Planning App. Ref Nos 3/2011/0821 & 3/2011/0822

Response from Chipping Parish Council

Chipping Parish Council welcomes the proposal to develop the Talbot Hotel site. This site is mentioned specifically in the Chipping Village Plan.

Proposed Site Plan

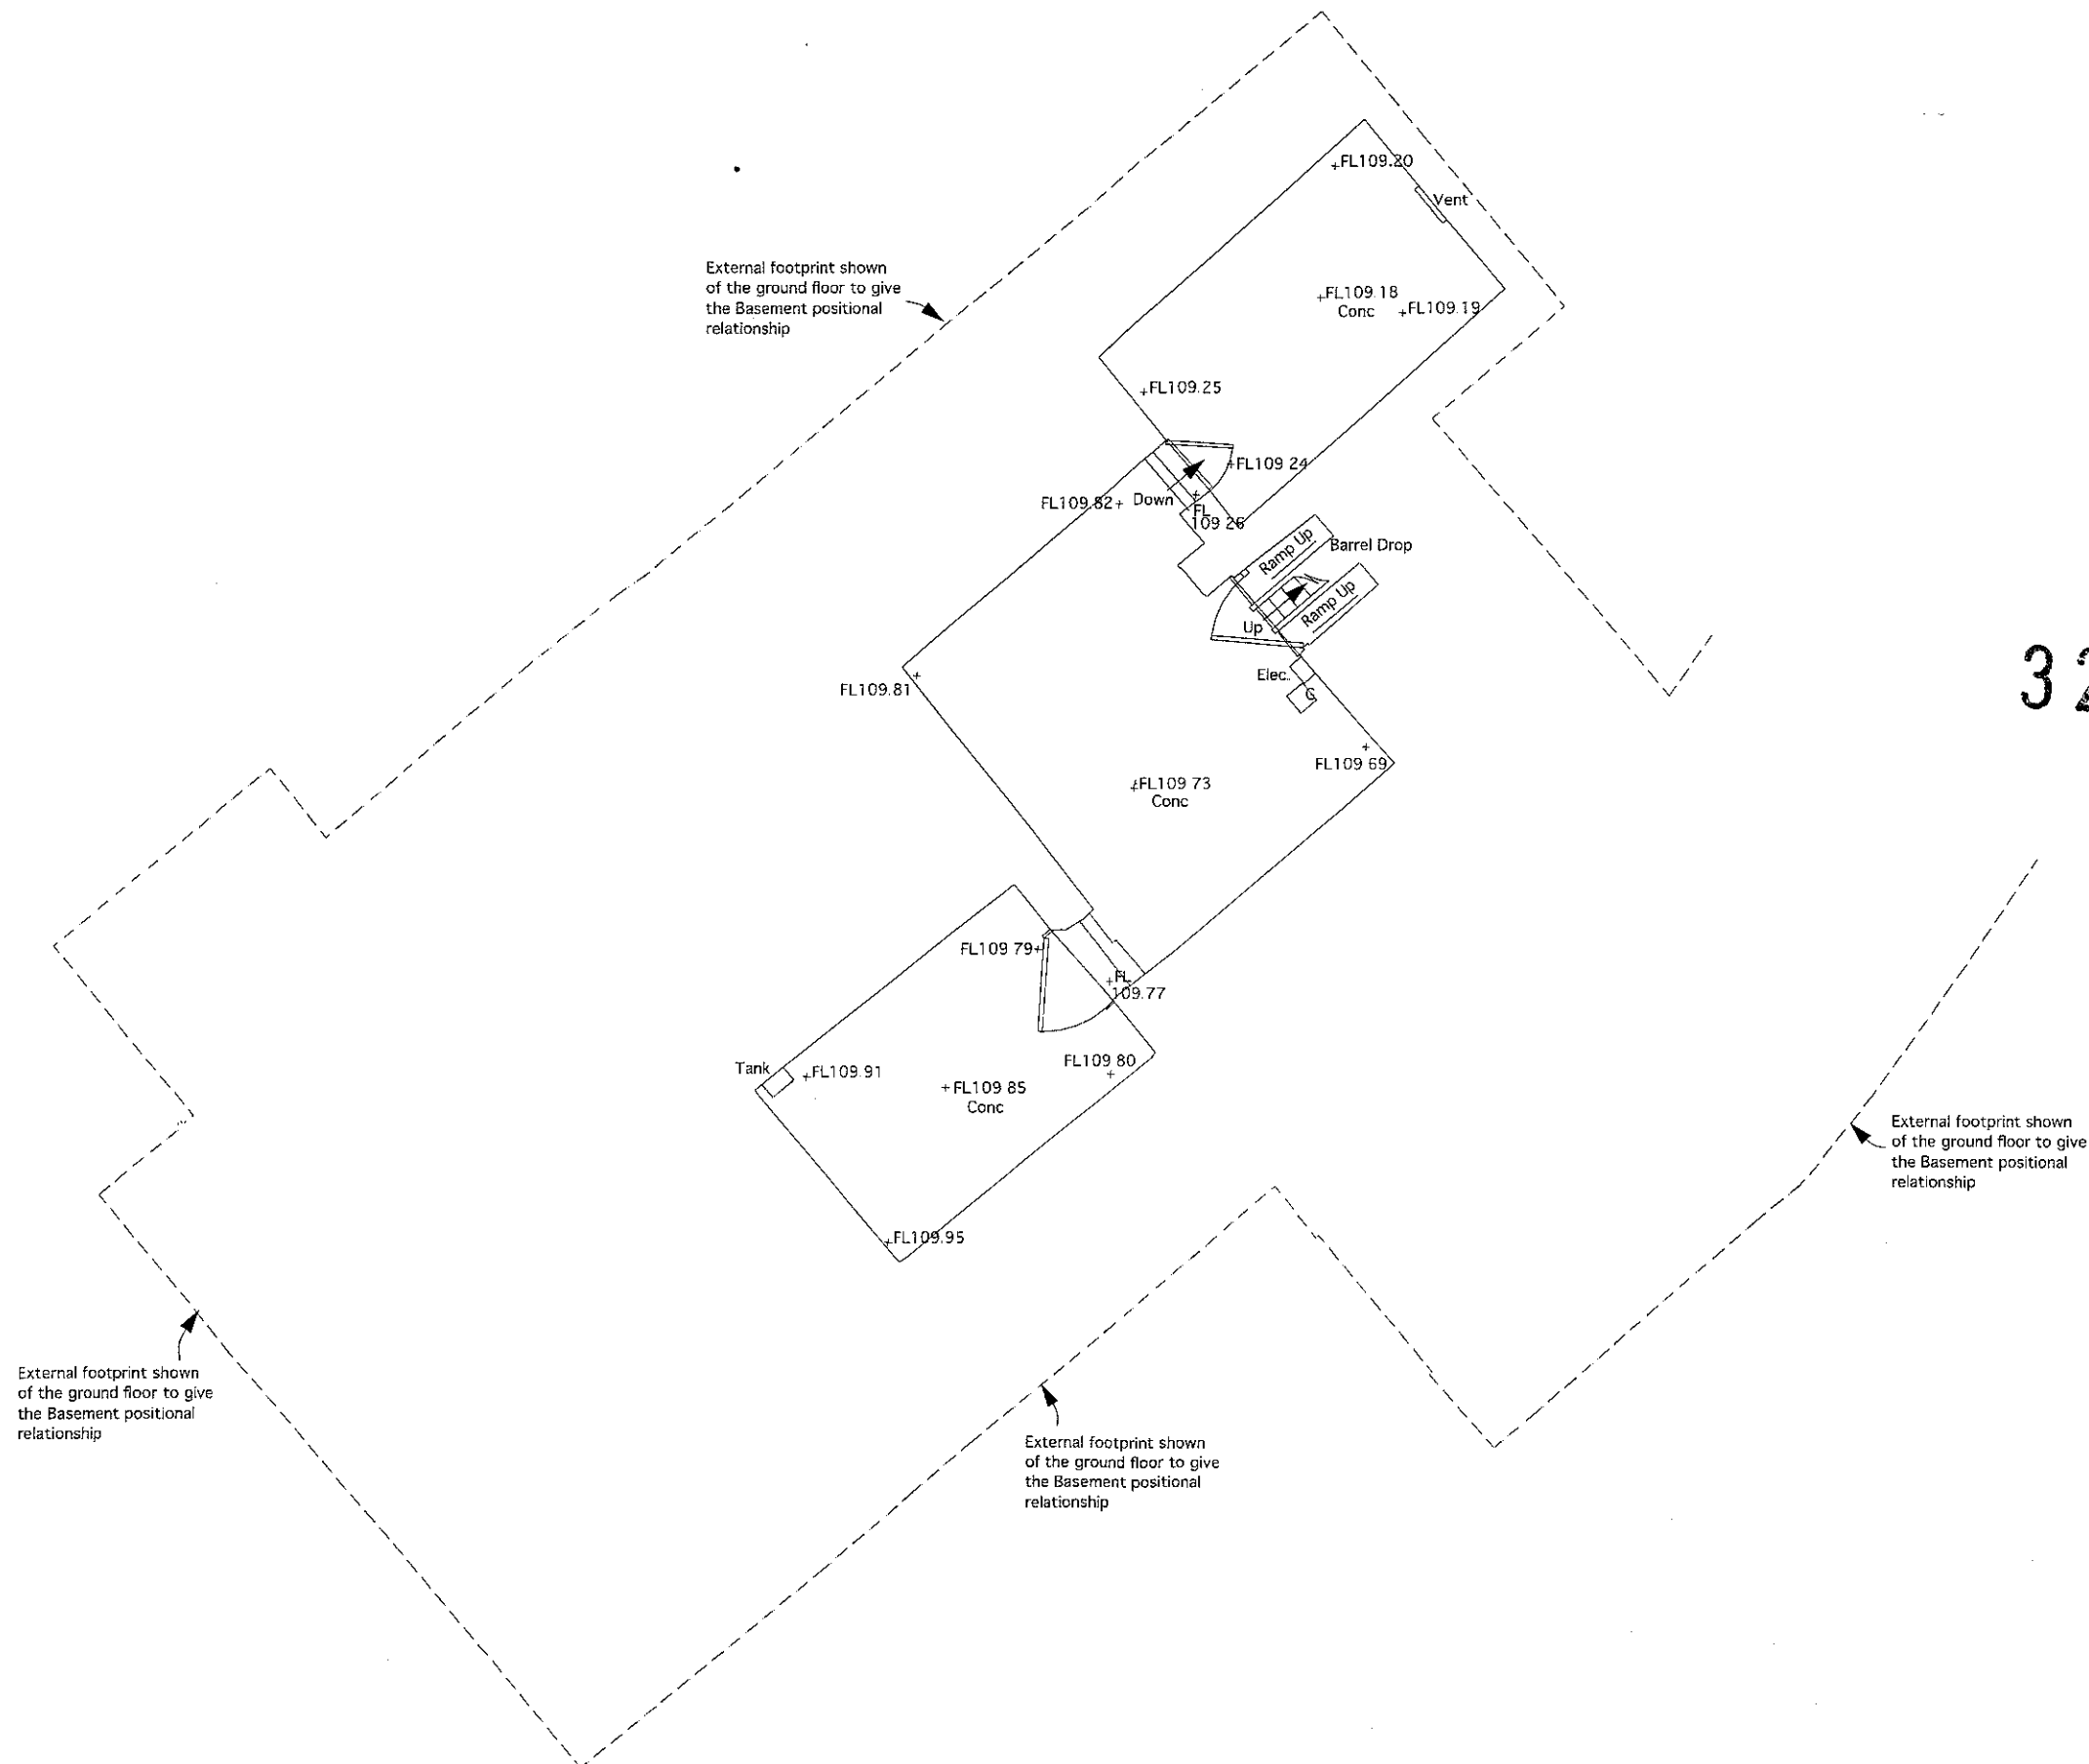
It is felt that the fifty car parking spaces allowed for the project is insufficient.

The Transport statement acknowledges there will be times when there will not be enough on site parking.

There are no spaces planned for staff cars. The planned policy suggestion that employees would either walk or cycle to work is laudable but unrealistic.

Access on to Talbot Street from the proposed car park is highlighted as a safety issue, as there is limited visibility of on coming traffic. Appropriate measures should be taken to mitigate the risks which will be assessed by L.C.C. Highways Department.
